Peartree Hill Solar Farm

Environmental Statement Addendum

Revision 8

Application Document Ref: EN010157/APP/8.2

Figure 7.1: Designated Sites and Ecological Mitigation and Enhancement Areas

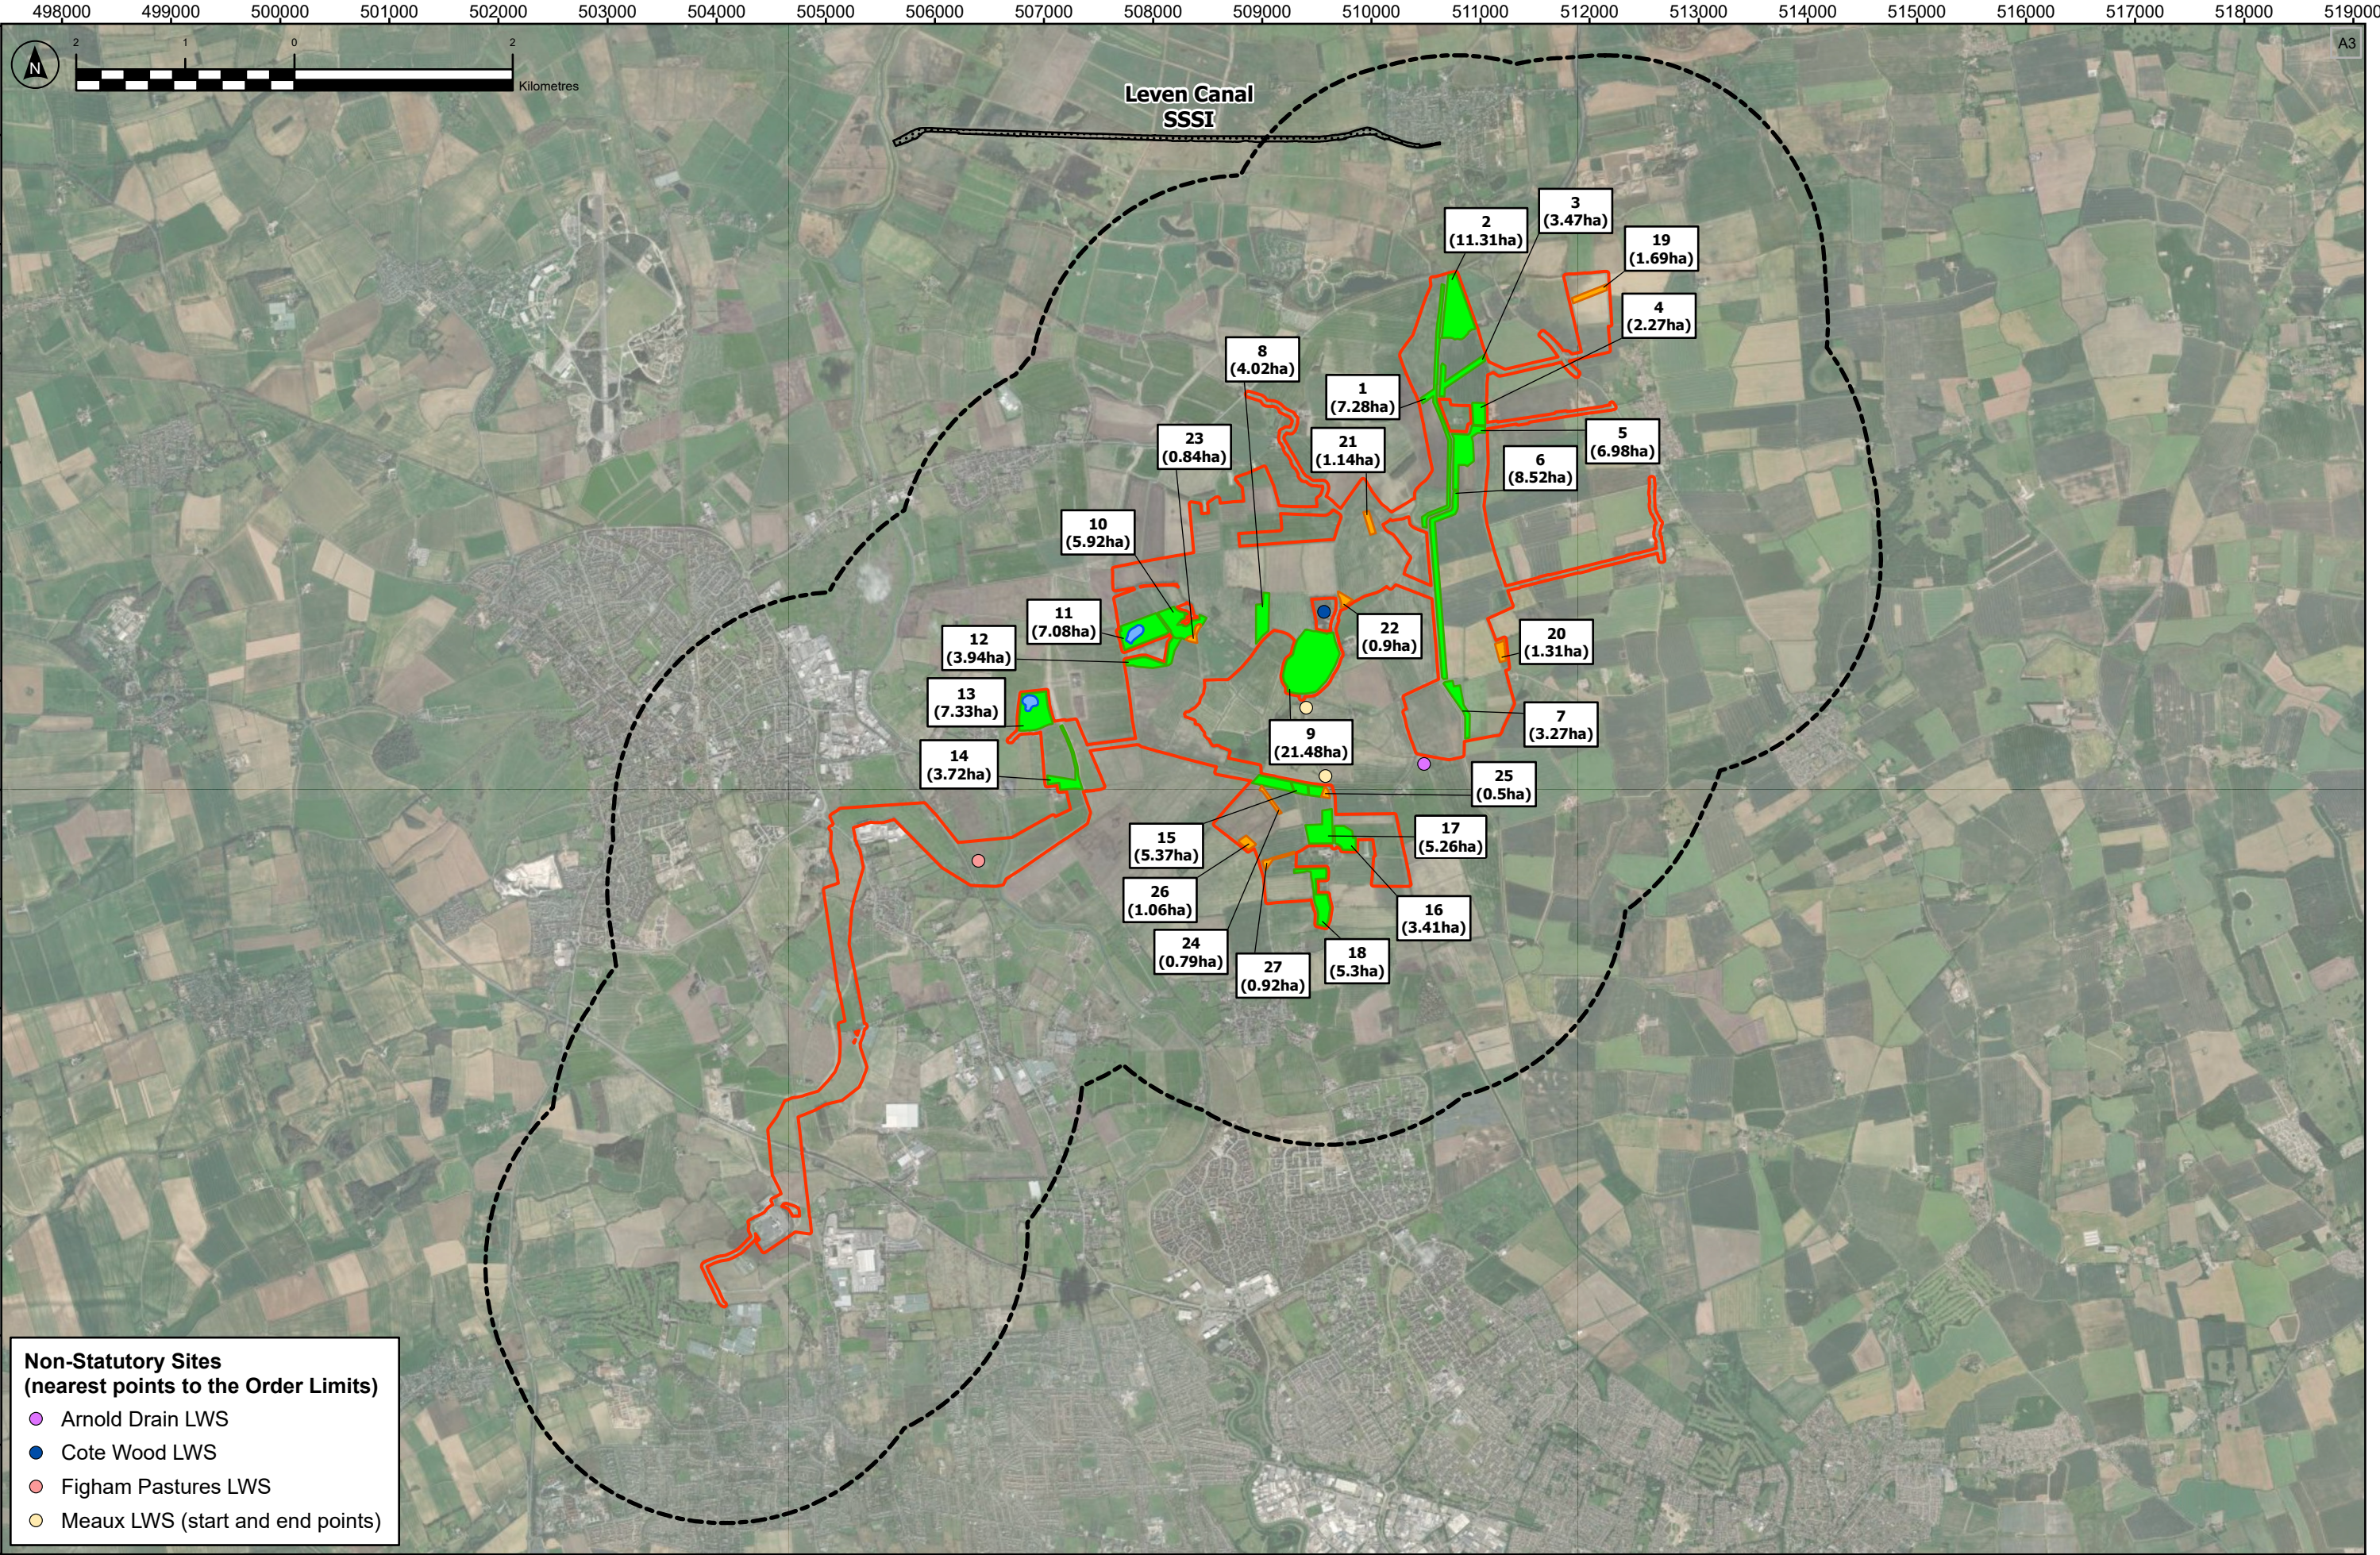
ES Volume 3, Figure 7.1: Designated Sites and Ecological Mitigation and Enhancement Areas [APP-065]	Figure 7.1 requires amendment to reflect the removal of plots 10-4, 10-5 and 10-6 as part of change/correction 2.	
ES Volume 3, Figure 7.2: Biodiversity Study Areas [APP-066]	Figure 7.2 requires amendment to reflect the removal of plots 10-4, 10-5 and 10-6 as part of change/correction 2.	
ES Volume 3, Figure 9.1: Cultural Heritage Study Areas [APP-067]	Figure 9.1 requires amendment to reflect the removal of plots 10-4, 10-5 and 10-6 as part of change/correction 2.

Figure 9.2: Assessed Designated Heritage Assets

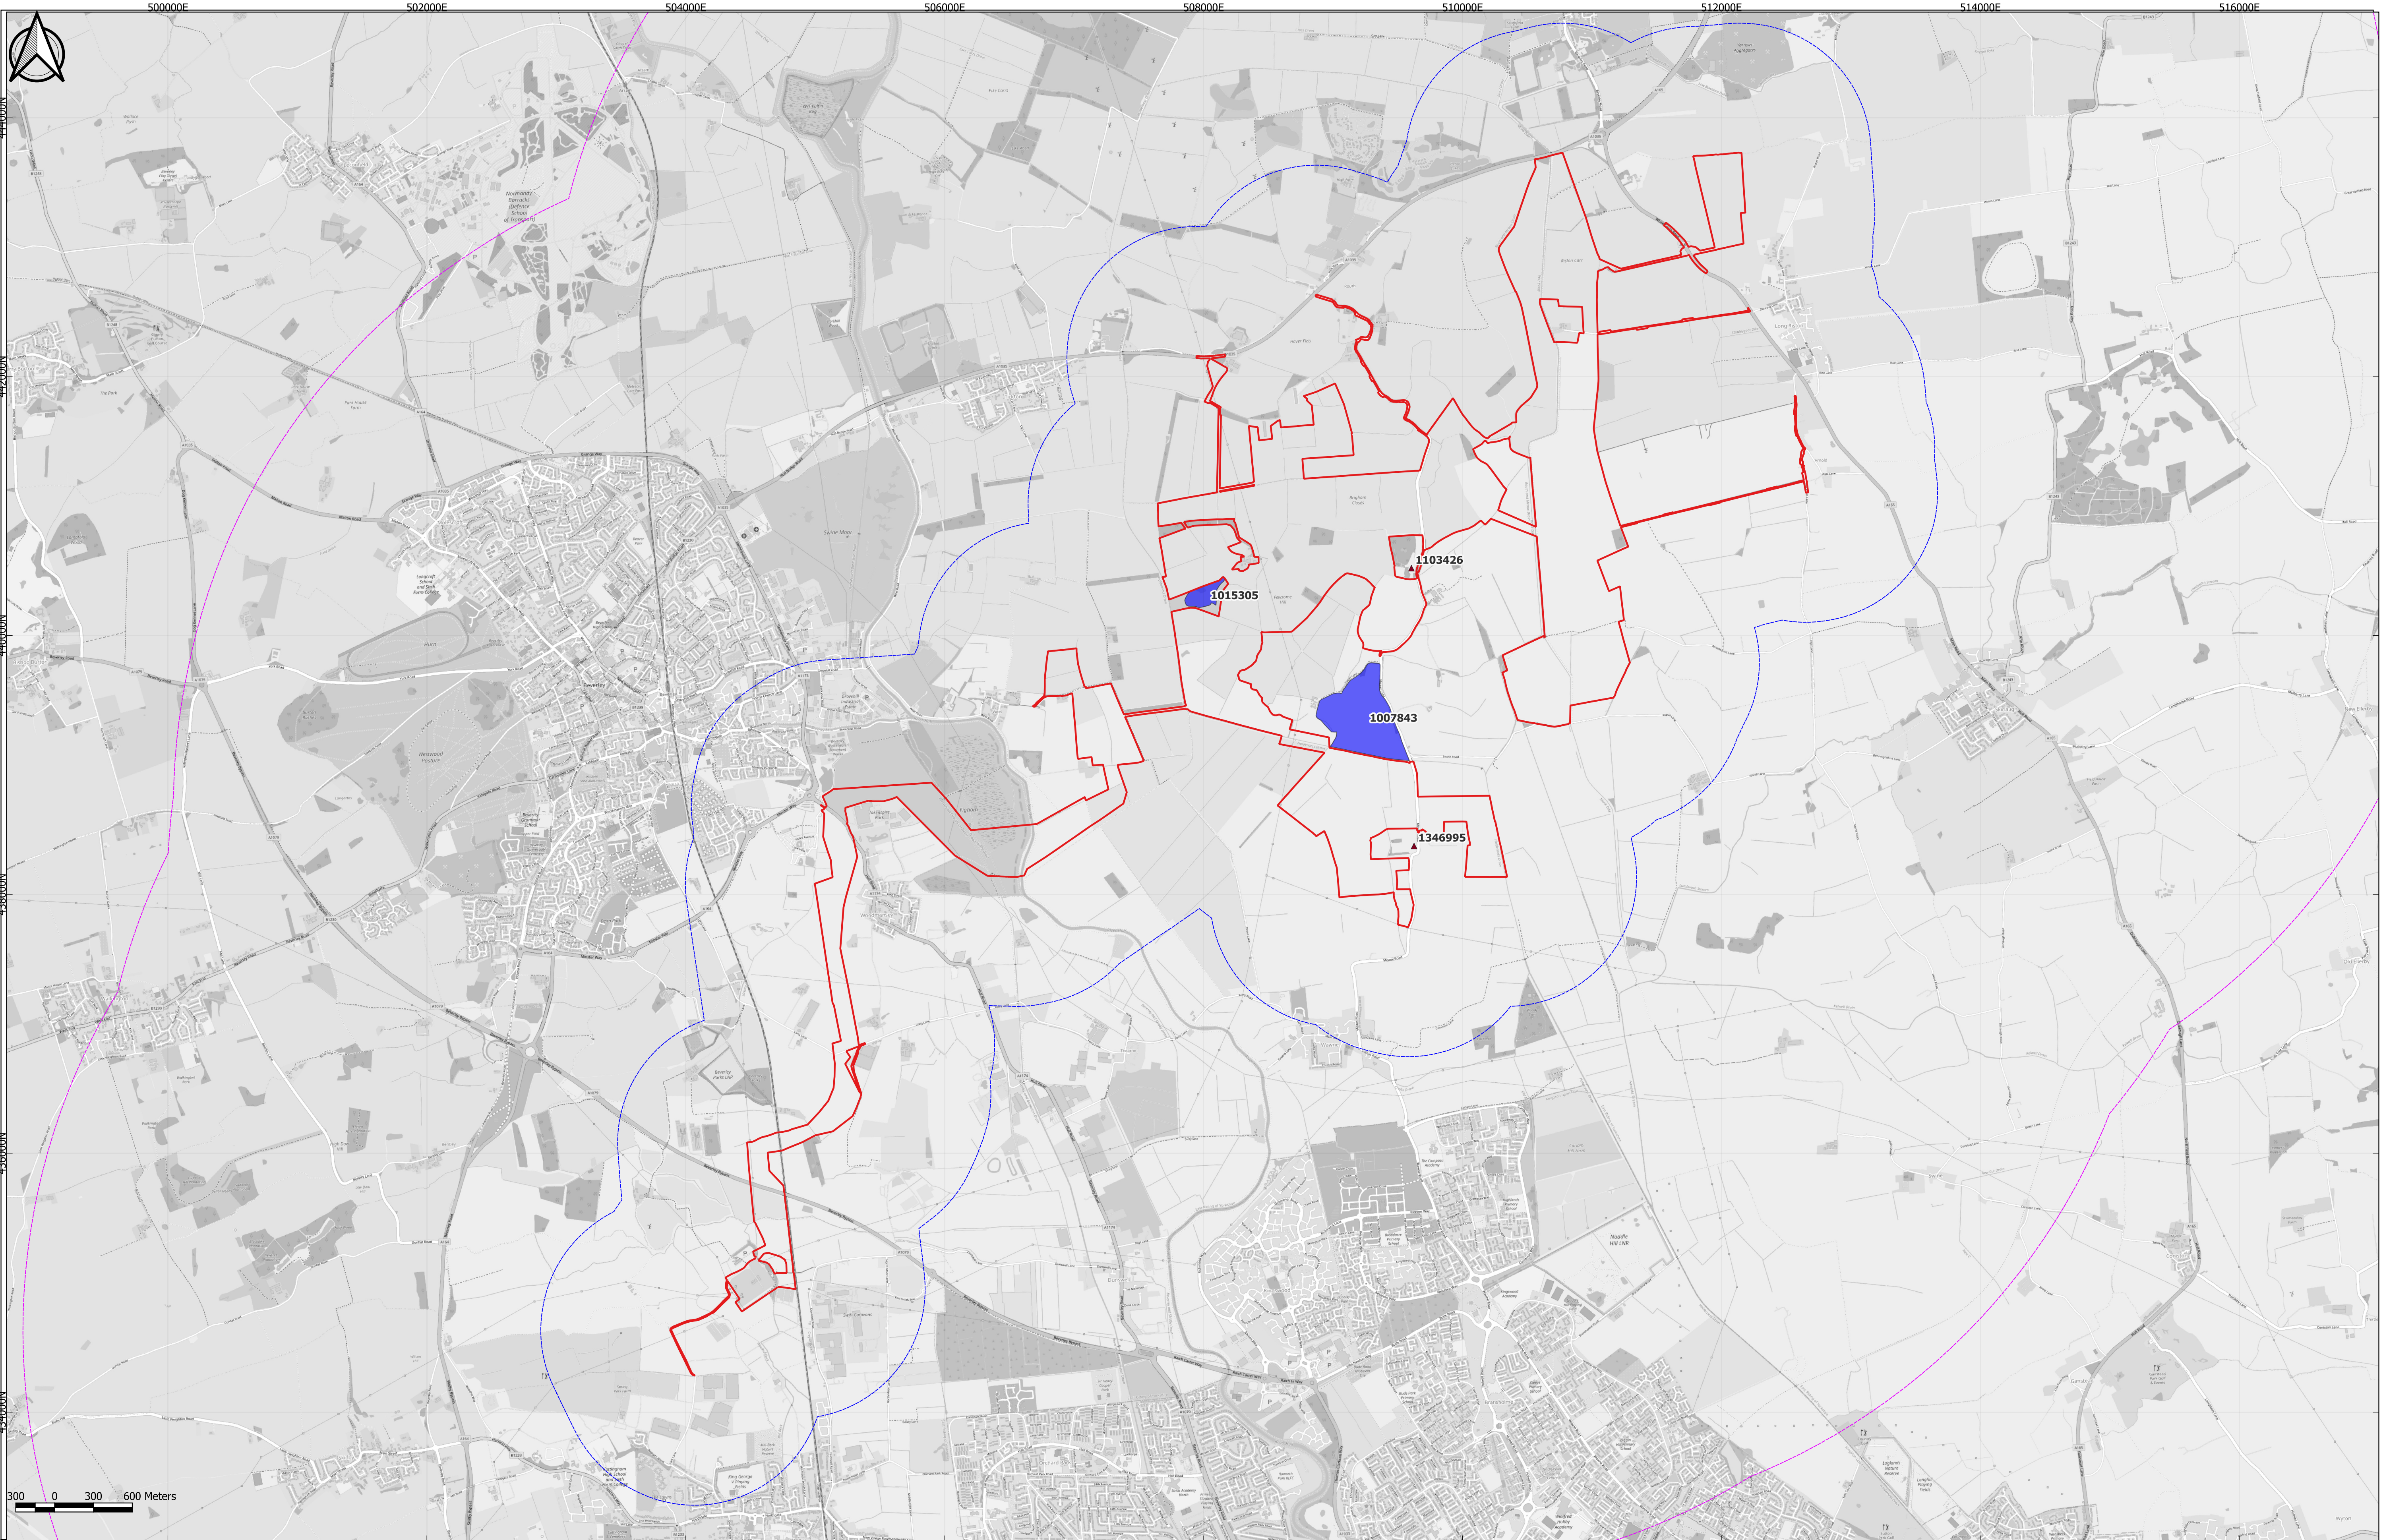
Document reference	Reason for amendment	ES Amendment July 2025
ES Volume 3, Figure 9.2: Assessed Designated Heritage Assets [APP-068]	Figure 9.2 requires amendment to reflect the removal of plots 10-4, 10-5 and 10-6 as part of change/correction 2.	
ES Volume 3, Figure 9.3: Assessed Non-Designated Heritage Assets [APP-069]	Figure 9.3 requires amendment to reflect the removal of plots 10-4, 10-5 and 10-6 as part of change/correction 2.	
ES Volume 3, Figure 10.1: Study Areas and Key Features for Land, Soil and Groundwater [APP-070]	Figure 10.1 requires amendment to reflect the removal of plots 10-4, 10-5 and 10-6 as part of change/correction 2.	
ES Volume 3, Figure 10.2: ALC Blocks overlaid Land Areas [APP-071]	Figure 10.2 requires amendment to reflect the removal of plots 10-4, 10-5 and 10-6 as part of change/correction 2.	
ES Volume 3, Figure 11.1: Landscape Study Area, Context, Designations and Access [APP-072]	Figure 11.1 requires amendment to reflect the removal of plots 10-4, 10-5 and 10-6 as part of change/correction 2. Figure 11.1 also requires amendment to reflect the removal of a section of solar array from Land Area B as part of change/correction 1.
